Pick n Payless Metal Recovery and Recycling Facility SSD 8375

Objective Reference: CD19/08873

TAB A – Detailed Comments on State Significant Application SSD 8375

**Figure 7: Proposed Development Traffic Generation**

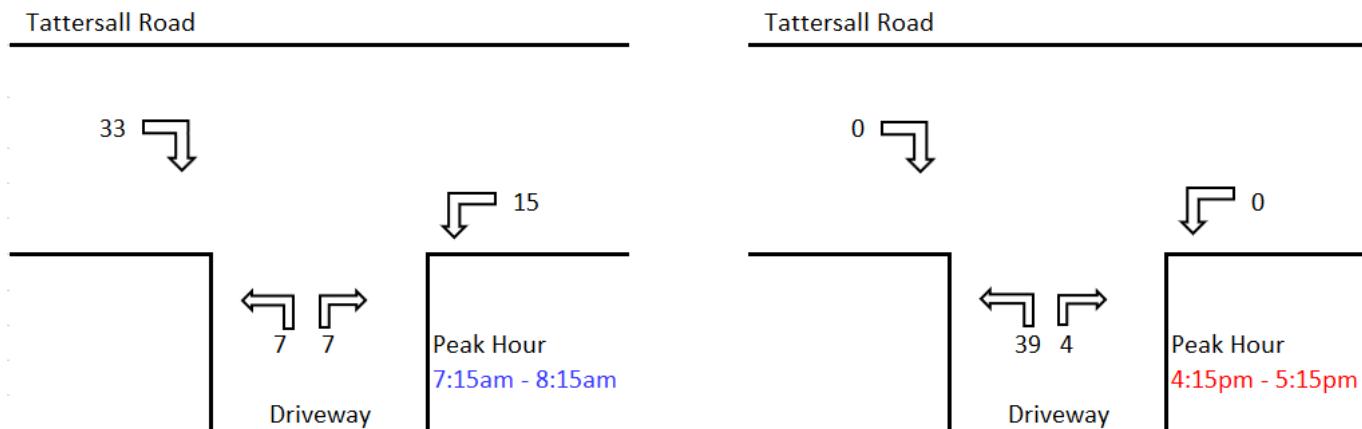
Appendix M (Page 12, Figure 7) provides proposed traffic distribution based on an existing driveway survey. Approximately, 2/3 of the proposed development traffic in the morning peak is shown to arrive from the west and all proposed development traffic in the afternoon peak is shown to depart to the west. Traffic entering or leaving the site in this direction will most likely be using the Vardys Road/ Tattersall Road intersection. However, no analysis of the performance of this intersection is provided in the EIS.

Furthermore, Page 8 of Appendix M states that it is expected that the vehicle movements will be evenly distributed throughout the day. It is unlikely that the traffic generation will be evenly distributed over the proposed 12-hour operation period of the development, which is supported by Figure 7, Page 12 in Appendix M. Accordingly, it is likely that the peak traffic generation provided in Appendix M is understated.

The EIS should be updated to include a performance analysis of the Vardy Road/ Tattersall Road and a revised traffic analysis which more accurately depicts the peak traffic generated by the development.

INTERNAL SWEPT PATH ANALYSIS - 19M ARTICULATED VEHICLES & 8.8M MR

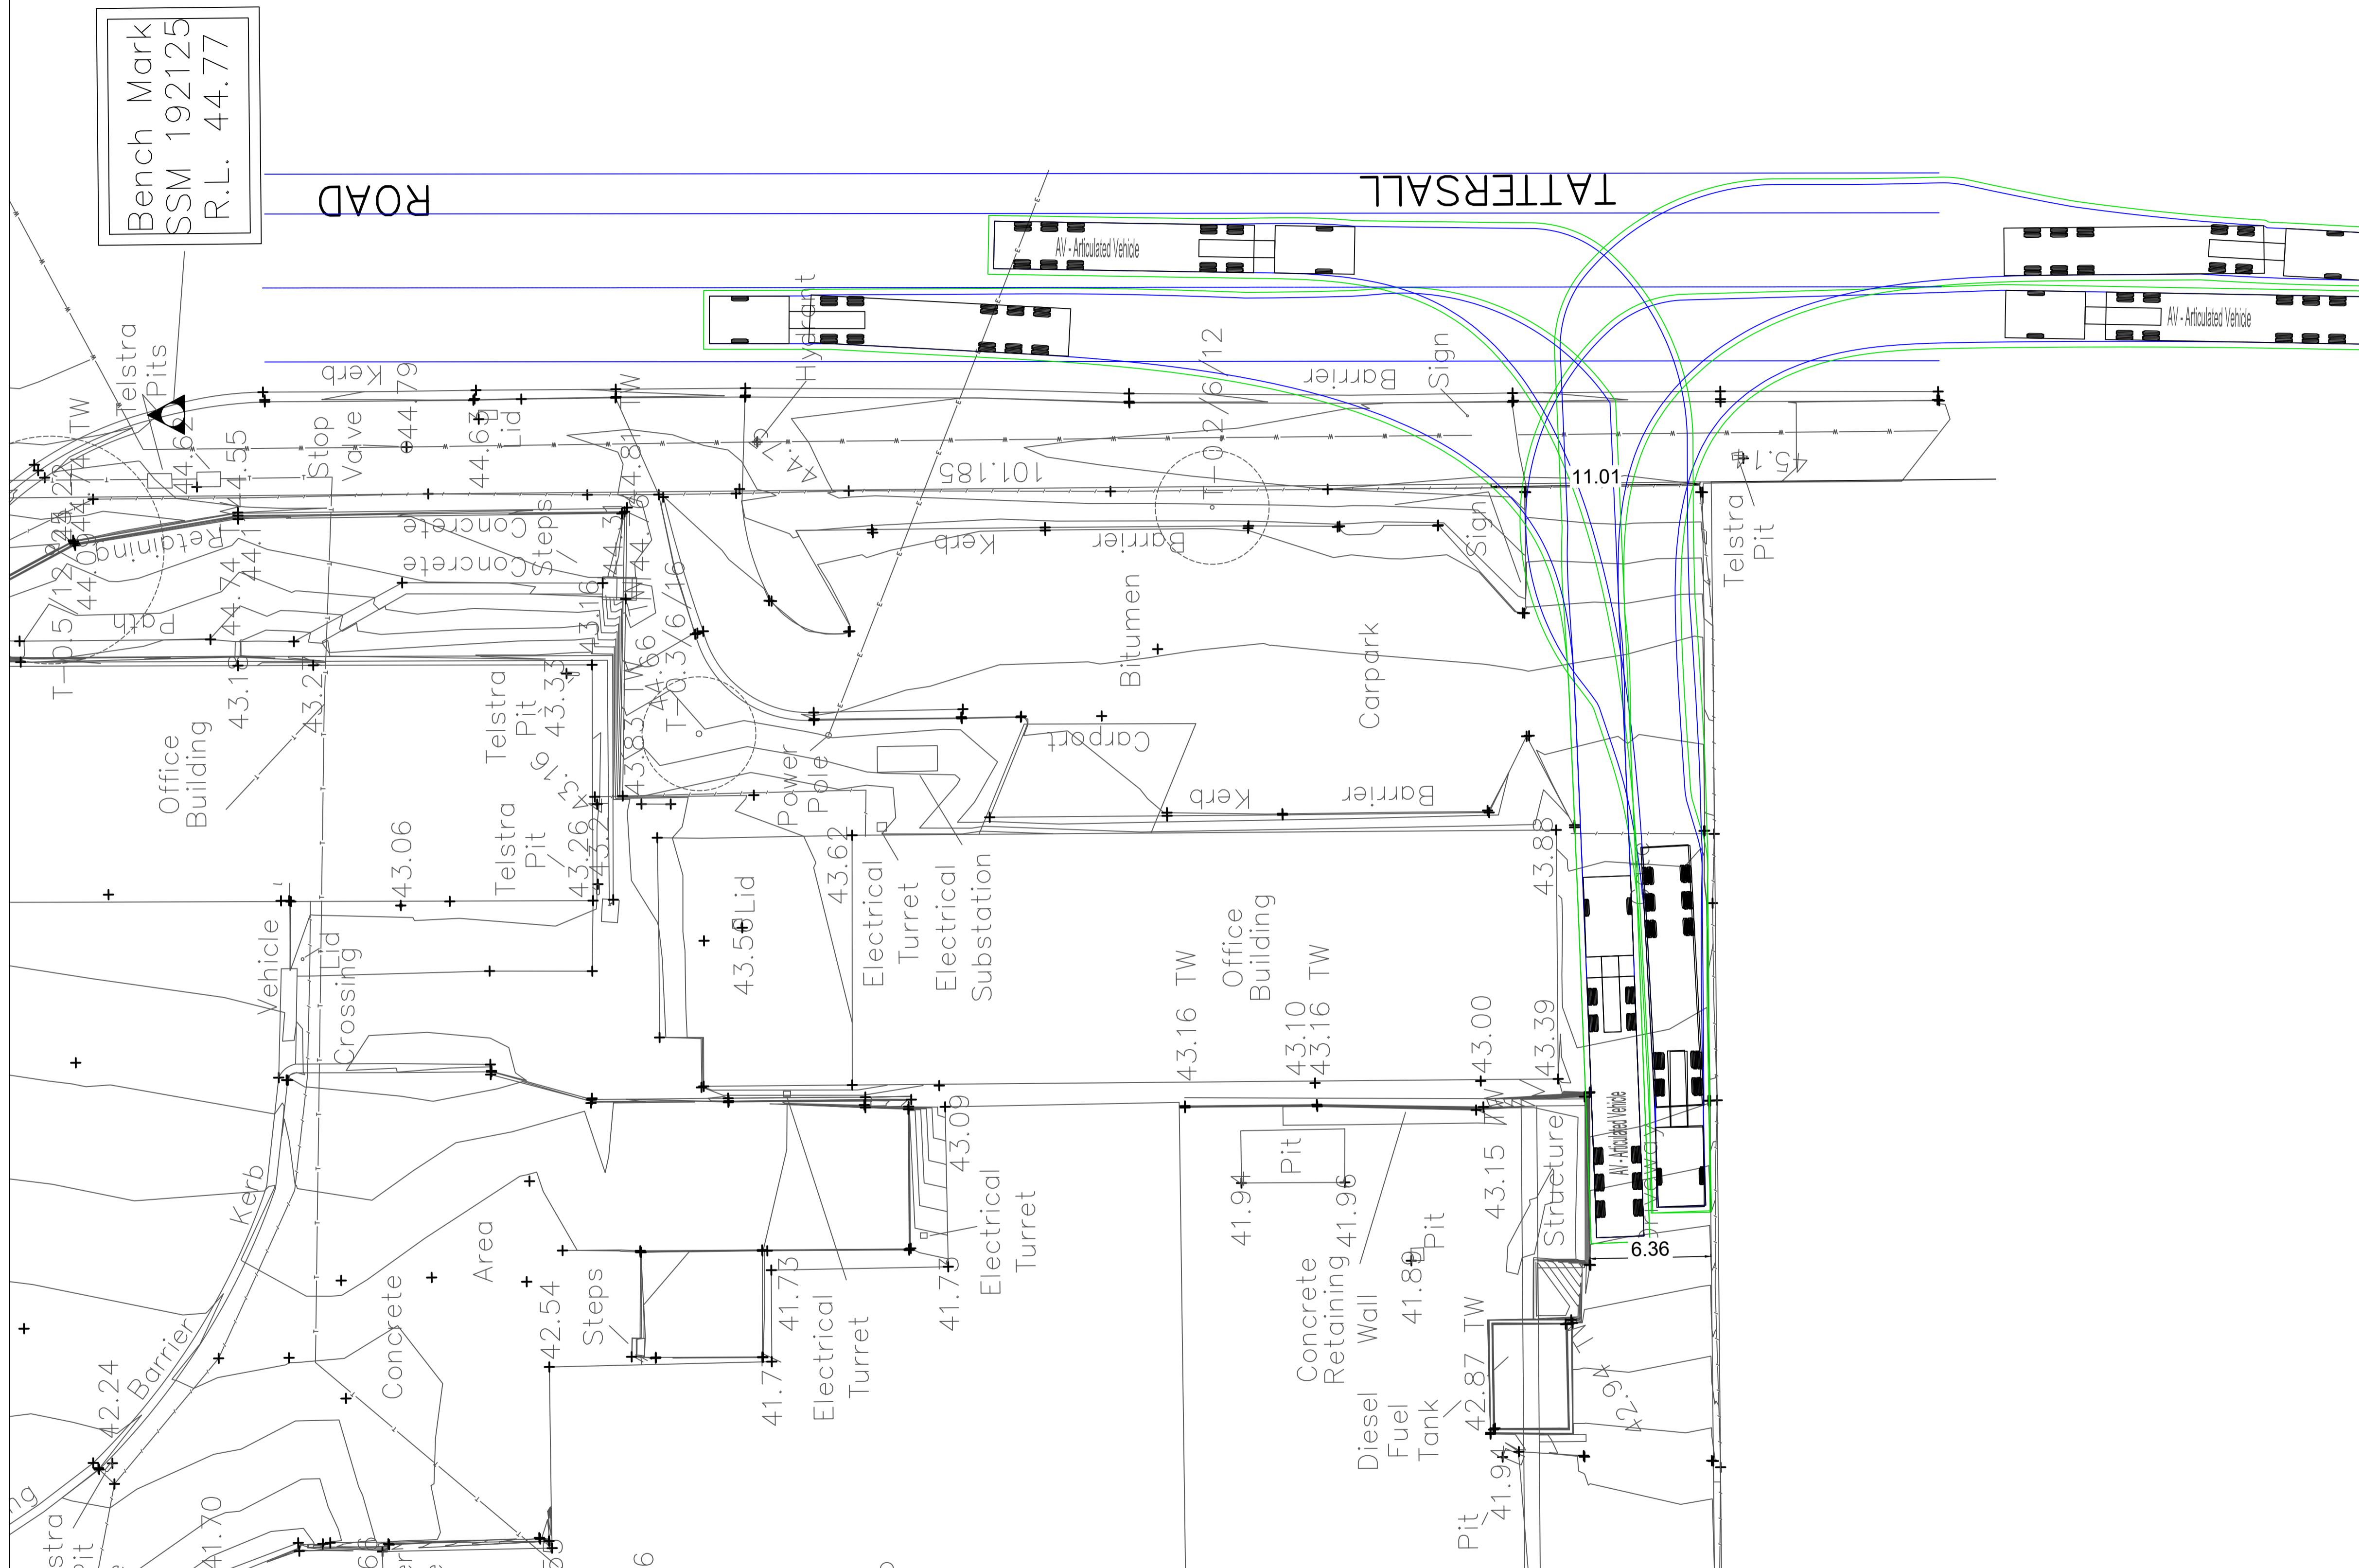
Furthermore, it is noted that the site is located within an existing 25 m B-double approved area, whilst the design vehicle for the internal road network is limited to a 19 m semi-trailer. This may restrict the ability of the site to take advantage of more productive vehicles in future.

Consider whether the internal road network should be designed to accommodate B-double vehicles to improve the efficiency of the development in future.
